WEST SUSSEX COUNTY COUNCIL CONSULTATION

TO:	Arun District Council - FAO: Amber Willard
FROM:	WSCC – Highways Authority
DATE:	3 July 2026
LOCATION:	Sefter Farm Pagham Road Pagham PO21 3PX
SUBJECT:	P/76/26/PL Construction of a new engineering block building and car parking areas together with a new access road, footpaths and hard standing area. This application may affect the setting of a listed building and is in CIL Zone 5 (Zero Rated) as other development.
RECOMMENDATION:	More Information

Swept Path Analysis Drawings

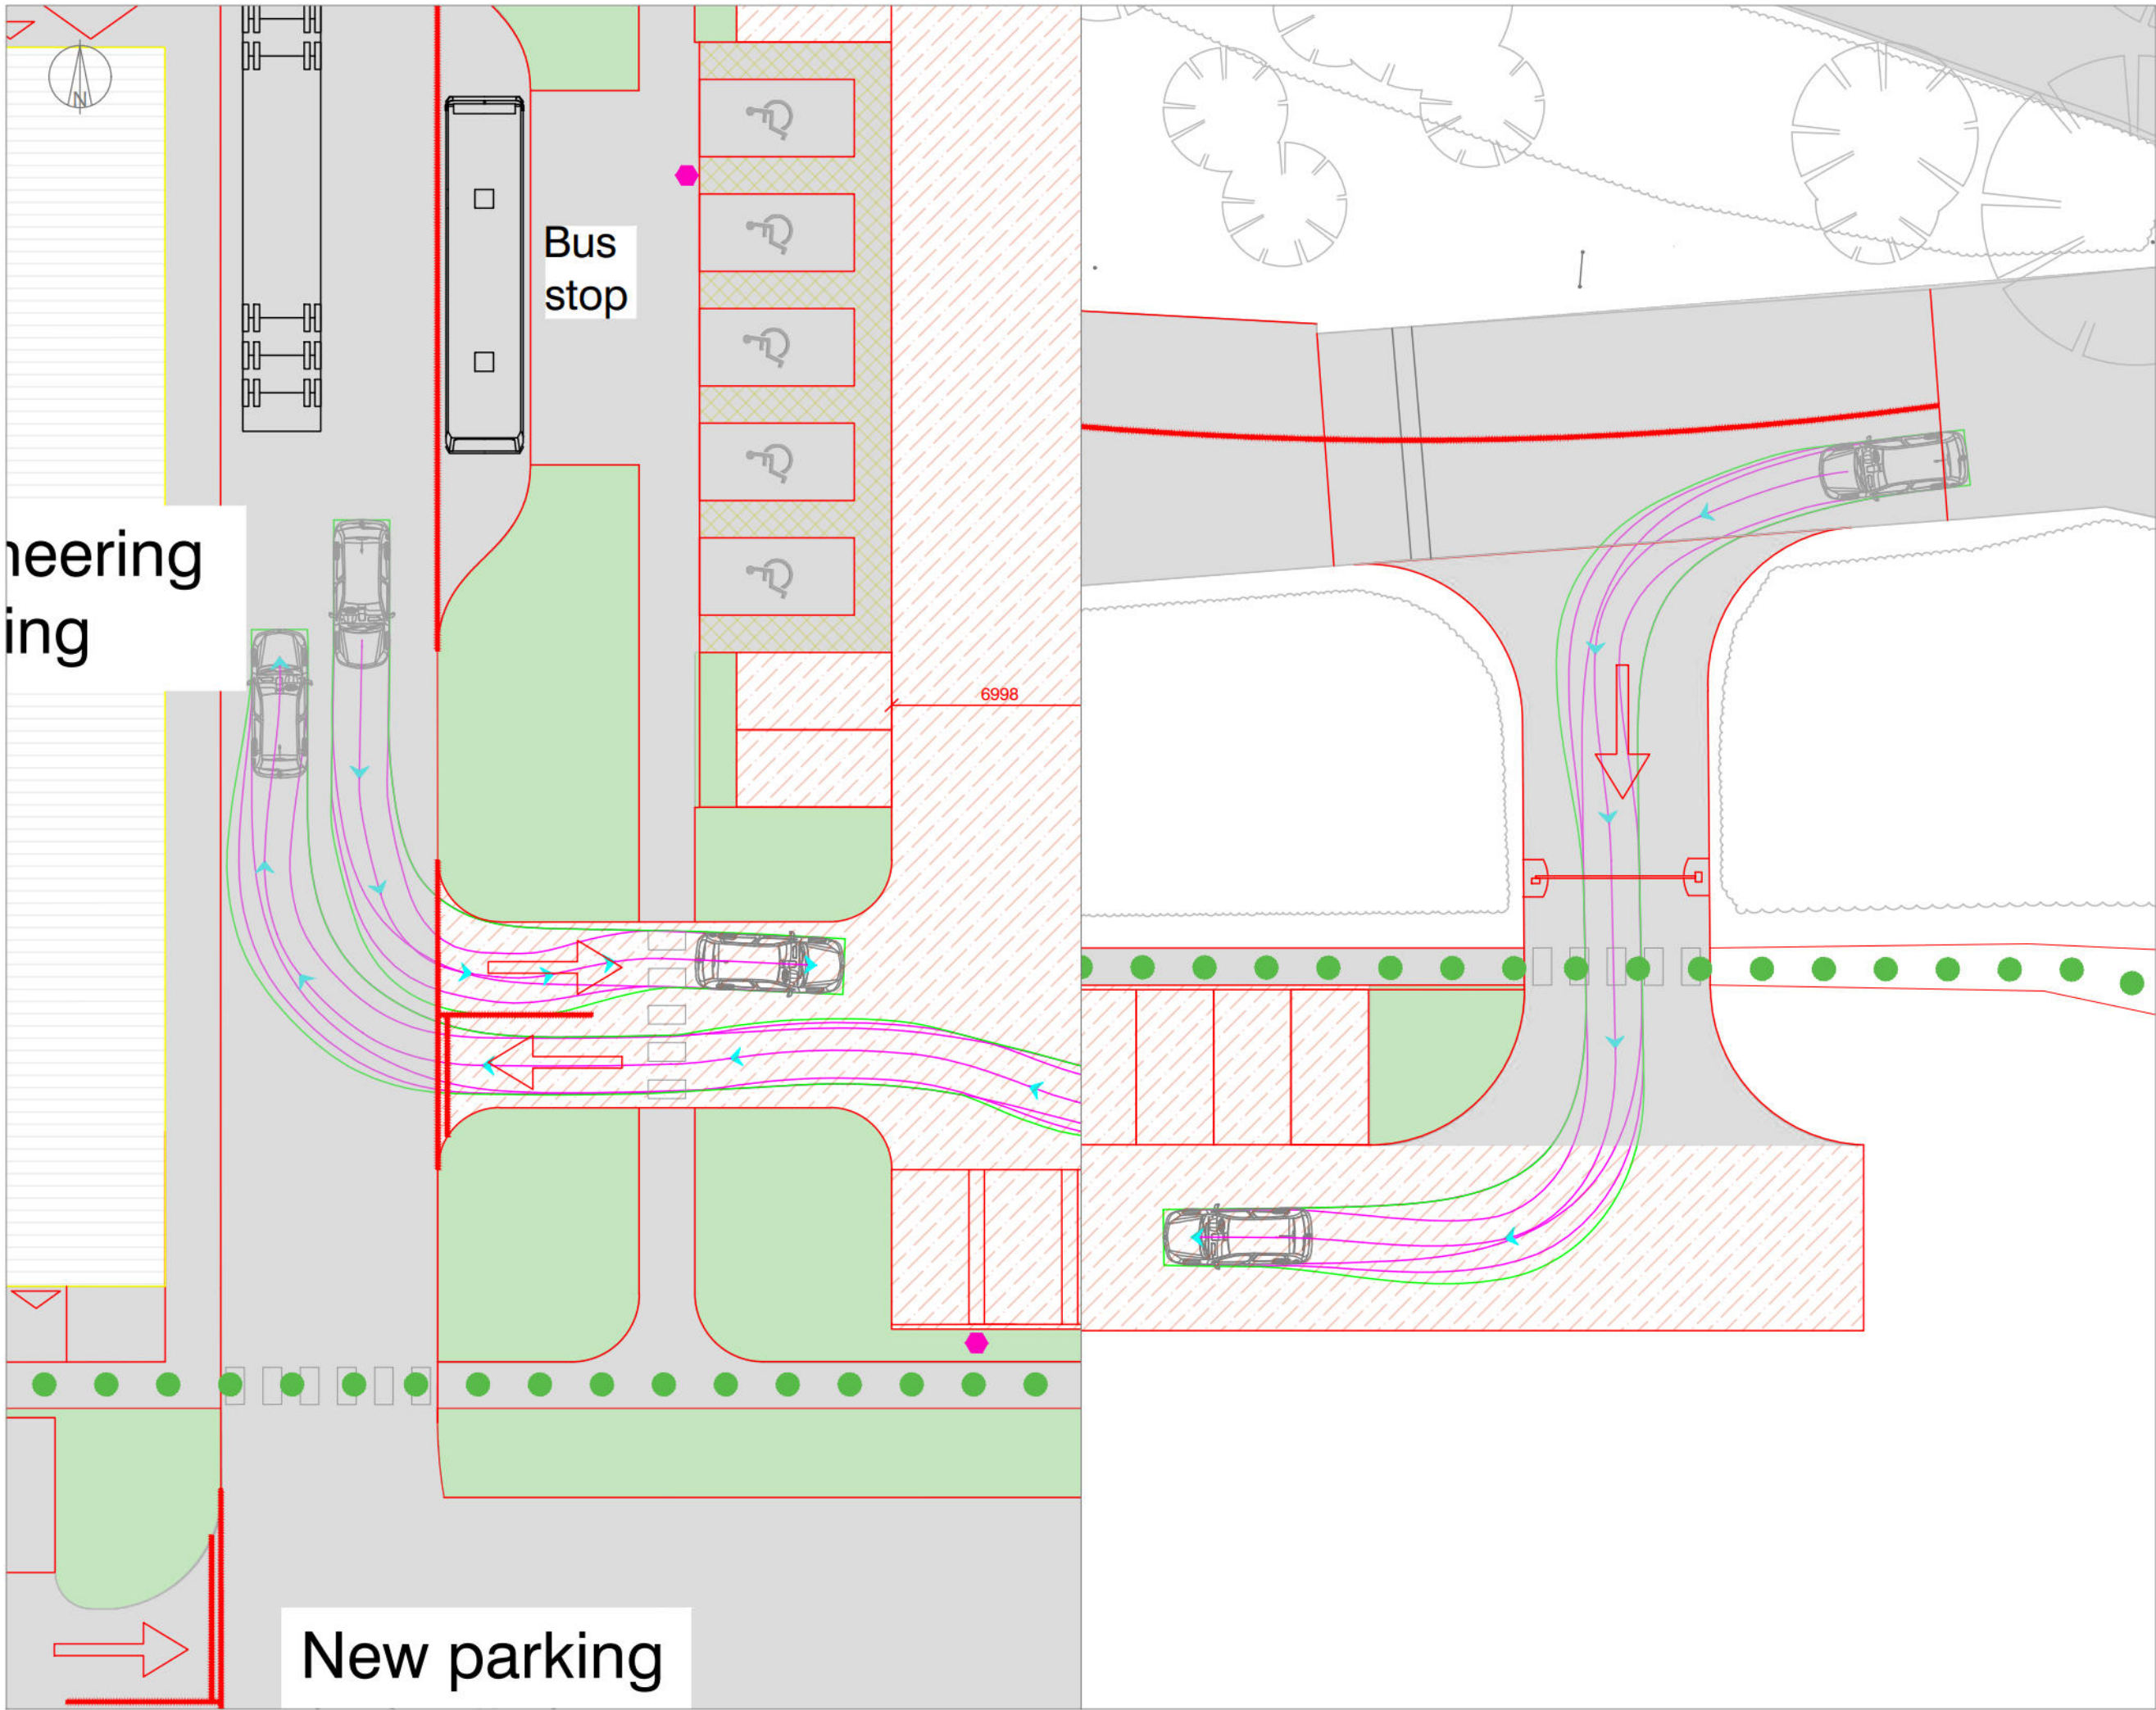
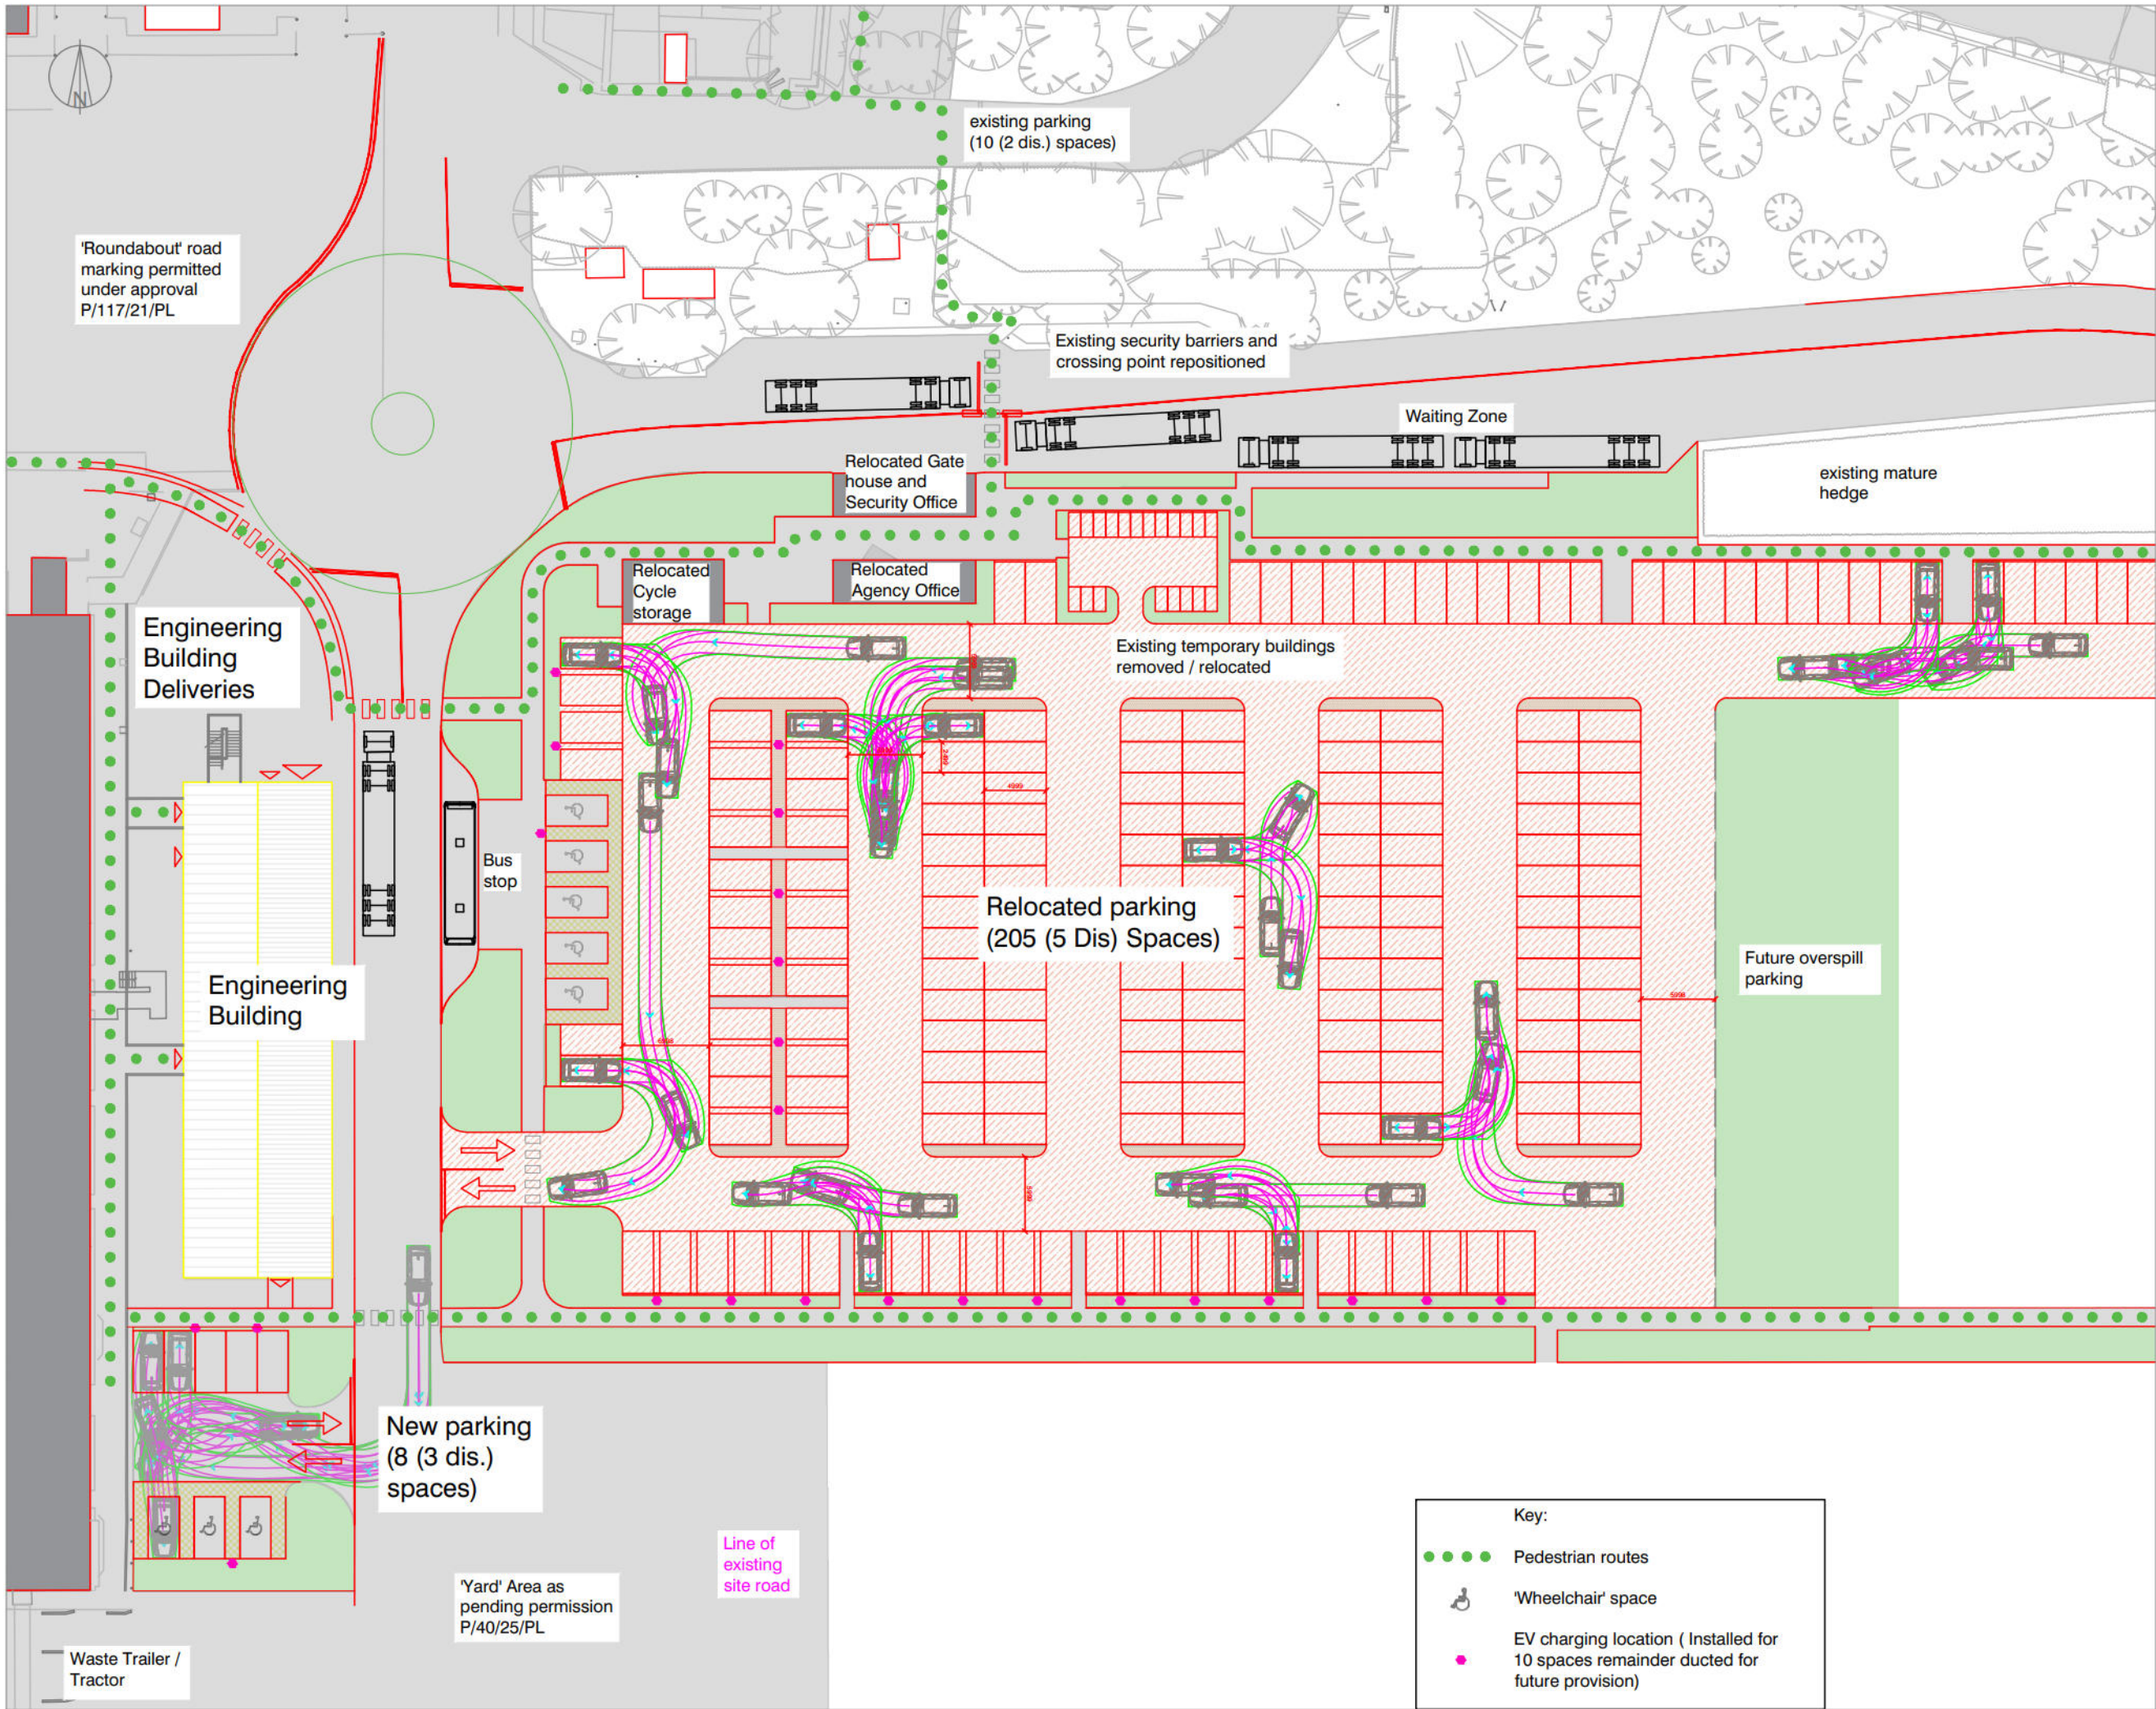
Whilst the site is rural and no cycle infrastructure on nearby roads exist, there is a bus stop to south at junction with Sefter Road with Chichester/Bognor service. However, Barfoots runs a bus service from within the site with services to Bognor/Littlehampton and Portsmouth for shift worker start/finish times. The internal bus stop will be relocated from along the main access road to west of the car park. It is advised that swept path tracking is provided to demonstrate workability including turning for bus.

- Updated TP.
- Swept path tracking for bus for new bus stop location, including turning on site.
